From: Grace Palmer [REDACTED]
Sent: 02 February 2022 11:54
To: Simon Davis
Cc: Christopher Best; Lauren Wiltshire; Tom Moody
Subject: RE: Land at Northfields Cottages, Eastergate BN/1/22/DOC
Attachments: 108.5009MMS3Land at Fontwell Avenue, Eastergate - SuDS Mgmt and Maint Plan(Bound).pdf; 108.5009 - PLOT 15 1in100rev a.pdf; 108.5009 - PLOT 18-20 1in100 rev a.pdf; 108.5009 - Plot 18 19 & 20 1in10- rev A.pdf; 108.5009 - Plot 15 1in10 Rev A.pdf

Subject: RE: Land at Northfields Cottages, Eastergate BN/1/22/DOC

PBA Drawing No. 108.5009.502 Revision E

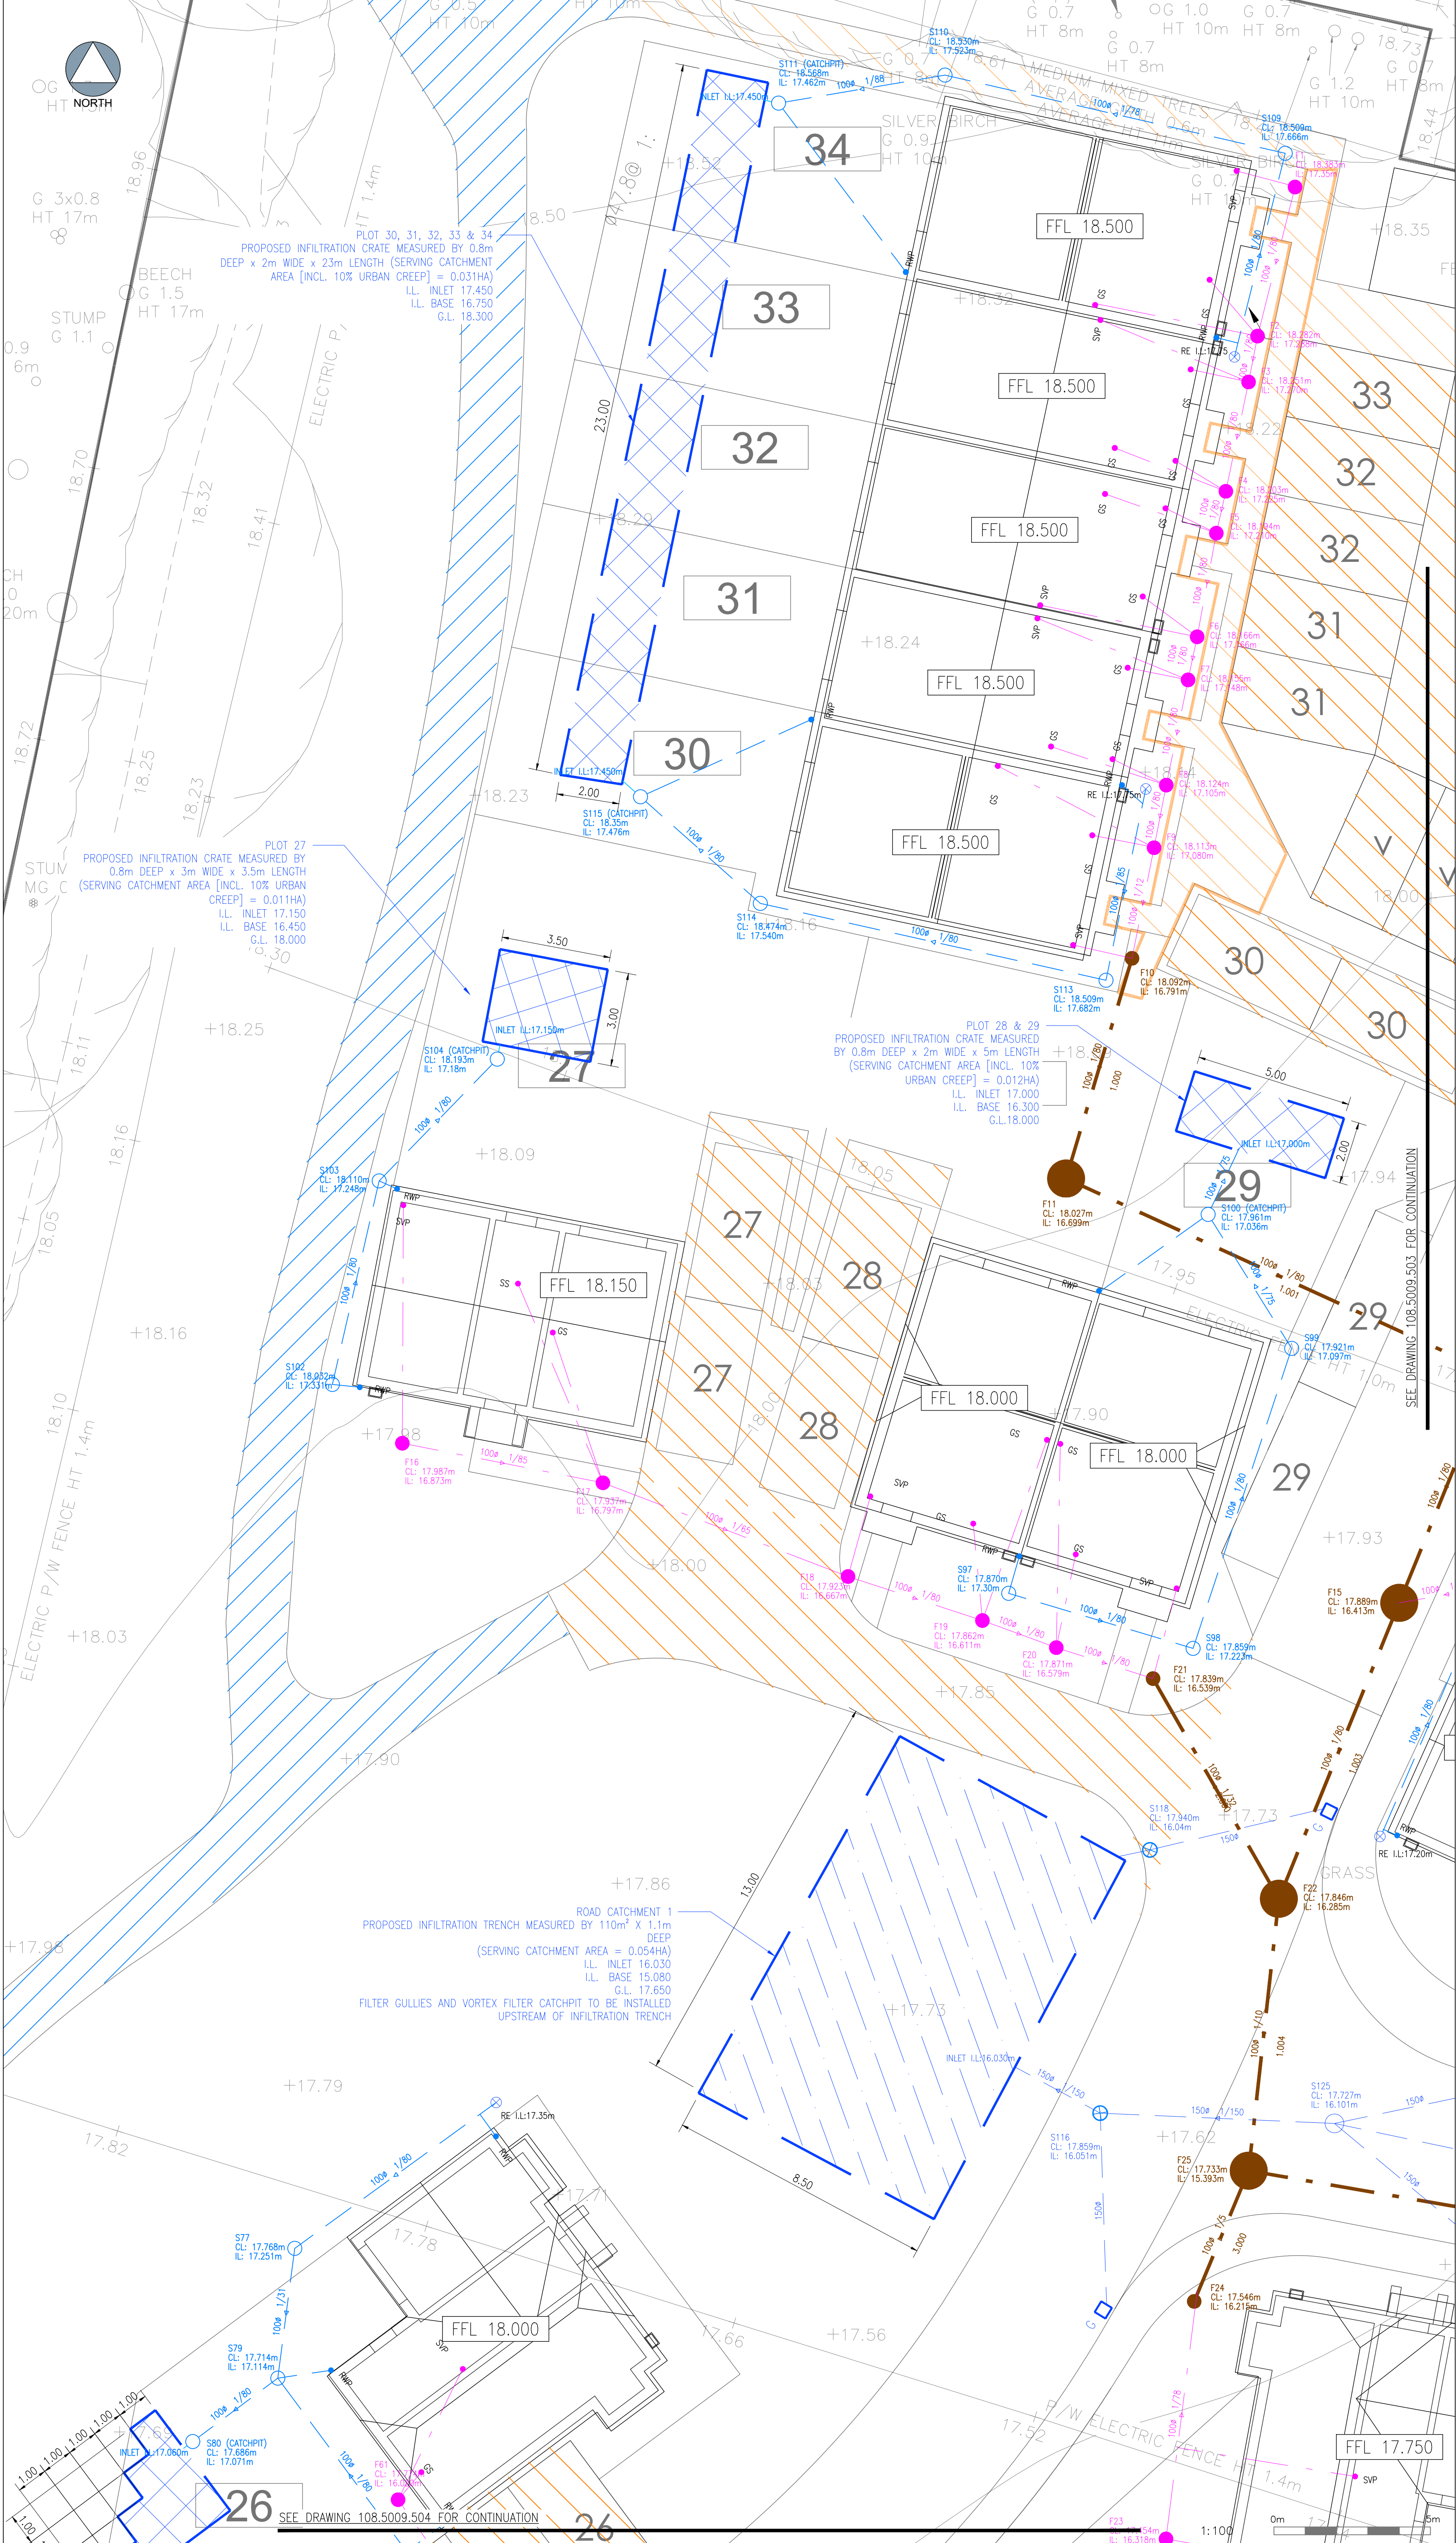
- Plot 18-20 soakaway shown as 20m in plan on drawings, 22m in calculations. Calculations and layout should be consistent. Noted, however since the infiltration is through the sides of the soakaway and not the base this makes no difference to the results. We have for completeness included updated calculations

- Plot 15 soakaway shown as 10m2 on layout, 25m2 in calculations. Calculations and layout should be consistent. Noted, however since the infiltration is through the sides of the soakaway and not the base this makes no difference to the results. We have for completeness included updated calculations
